DOC18/491728-10

**Springdale Solar Project – State Significant Development (SSD 8703) – Review of Environmental Impact Statement**

I refer to your request for the Office of Environment and Heritage (OEH) to review the information provided on the Springdale 120 Megawatt Solar Farm State Significant Development (SSD).

SCREEN PLANTING PALETTE

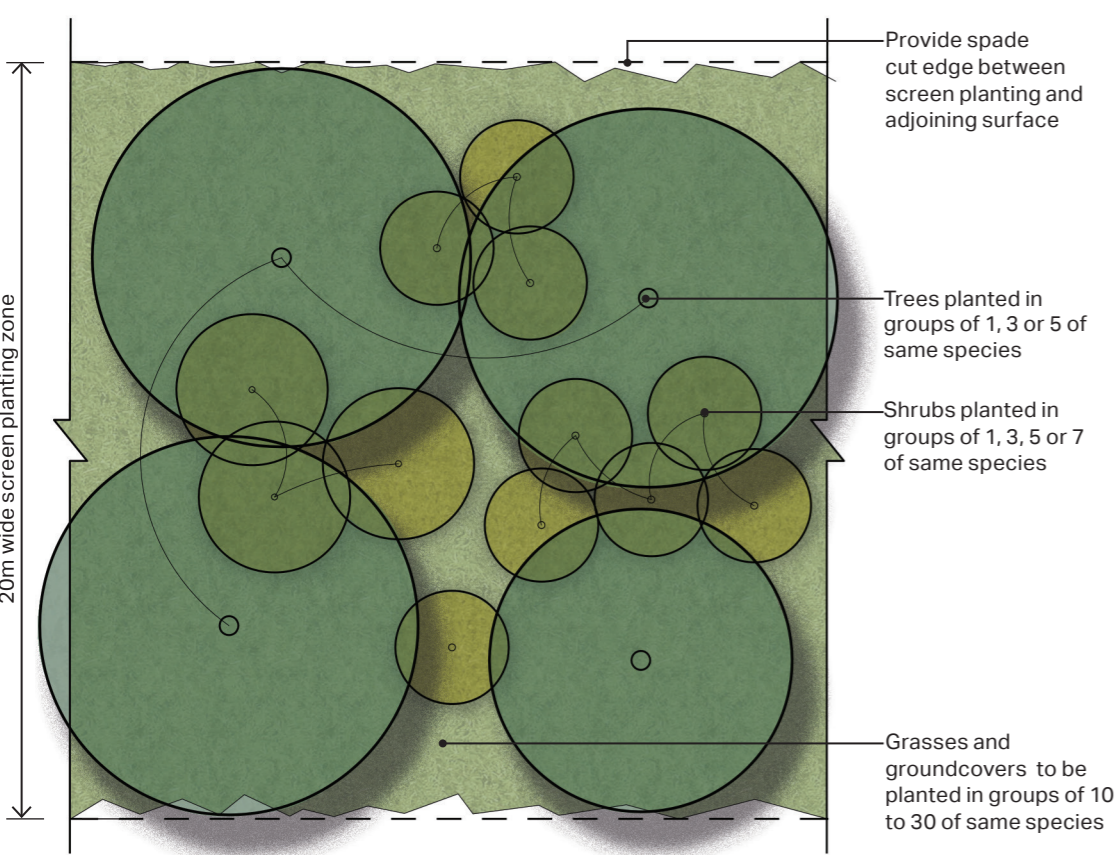
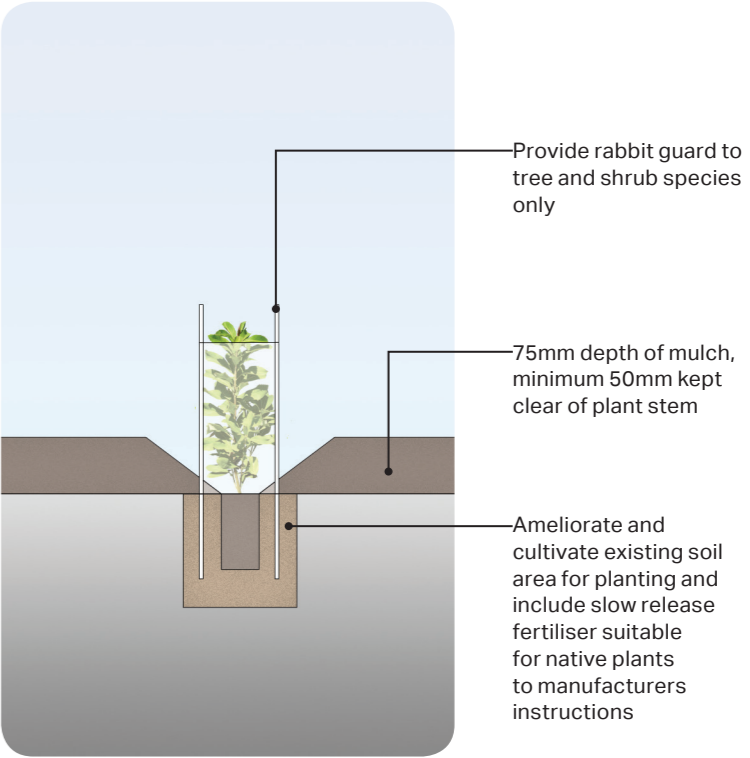
The Draft Landscape plan L01 shows a proposed 20m wide tree planting along the boundary. The impact of these plantings has not been considered. The trees will eventually shade out some of the known occupied habitat of Golden sun moth and potentially affect movement of the moth between patches of habitat on site and the population to the east of the boundary. Ideally, trees should not be planted in this area. Alternatively, the area that will be shaded should be considered cleared for the purpose of calculating credit requirements for the Golden sun moth.
